DELEGATED HOUSEHOLDER DECISION

Item No.	Report of the Head of Development Management and Building Control		
Address:	15 BRIDGE WAY ICKENHAM		
Development:	Erection of single storey ground and first floor rear extension together with the conversion of roof space to habitable use to include a rear dormer, 2 front roof lights and conversion of roof from hip to gable end.		
LBH Ref Nos:	5899/APP/2023/3421		
Drawing Nos:	Location Plan Existing V1 Block Plan V1 Proposed V2		
Date Plans received:	27-11-23	Date(s) of Amendments(s):	27-11-23
Date Application valid	01-12-23		27-11-23
			12-01-24

Block plan
Size: A3
Scale: 1:200
Ver: 1

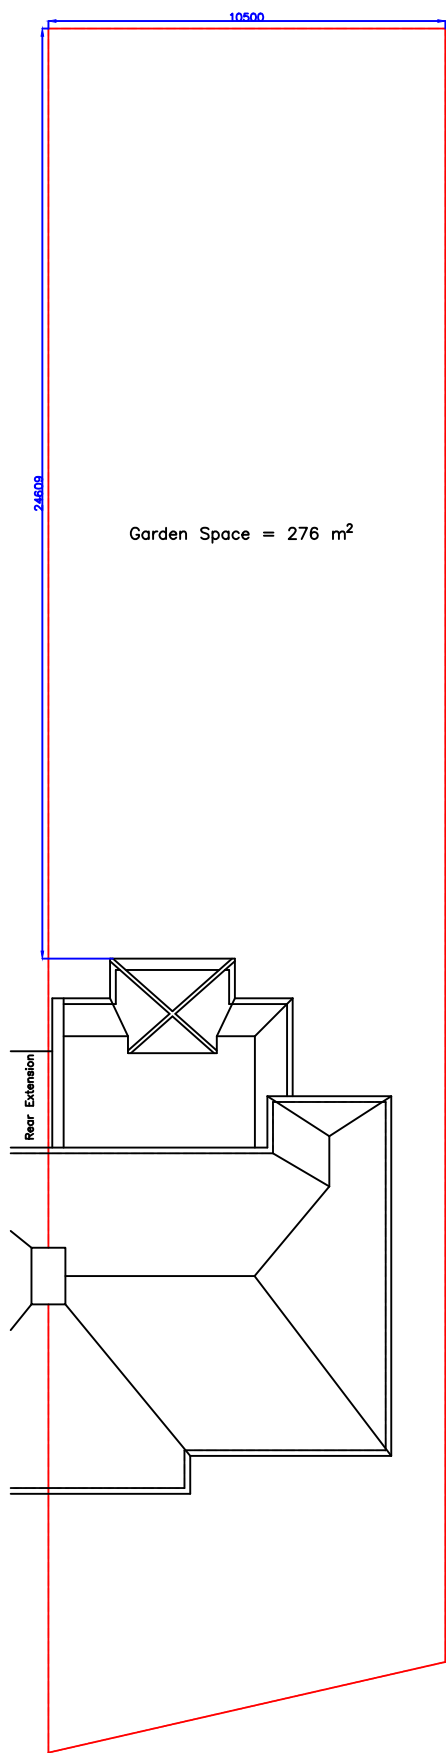
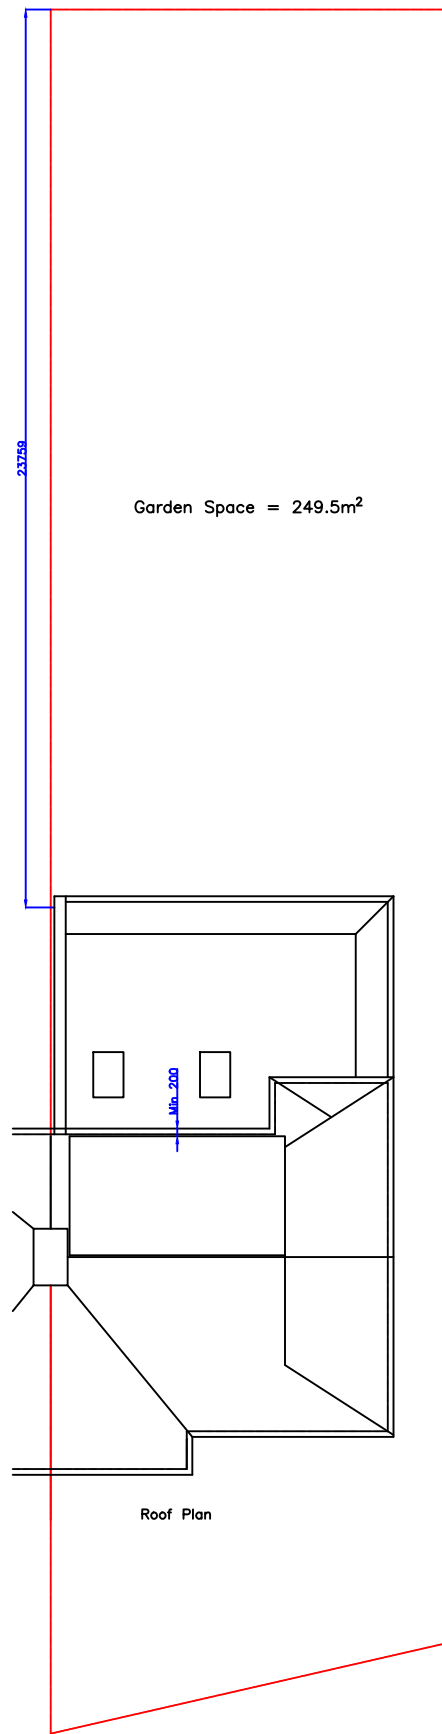
No. 14 is located to the southwest of the site and comprises a two-storey semi-detached property. The building line staggers significantly between No. 14 and the application site, with No. 14 located to the rear of No. 15. In this regard, the rear extension would not protrude beyond the rear building line at No. 14 and is unlikely to result in unacceptable overshadowing or a loss of light. There is one window proposed on the southwestern elevation facing No. 14, however this would be screened by the existing boundary treatment and would not result in overlooking or a loss of privacy.

No. 16 is located to the northeast of the site comprises the adjoining property. The neighbouring property benefits from a small single storey rear extension along the boundary with the application site. The neighbouring extension measures a depth of approximately 2.5m, and a width of 3m. The proposed rear extension would protrude 3.66m from the neighbouring rear extension. However, by virtue of the depth of the extension and the relatively small scale of the neighbours extension, it is considered that the proposal would result in an unacceptable oppressive and overbearing form of development which would result in an unacceptable loss of light to and outlook from, and a sense of enclosure to the occupants of this property, including both the garden/amenity space and habitable rooms, in conflict with Policies DMHB 11 and DMHD 1 of the Hillingdon Local Plan - Part Two (2020).

The proposed single storey rear extension, by reason of its cumulative size, design and proximity to the shared boundary, would result in an overly dominant feature that is incongruous with the prevailing pattern of development, resulting in harm to the character of the area, and would harm the residential amenities of the adjoining property at No.16 Bridge Way, through loss of light to and outlook from this property, and through creating an overbearing sense of enclosure. Therefore the proposal would be contrary to policies DMHB11 and DMHD1 of the Hillingdon Local Plan - Part Two (2020).
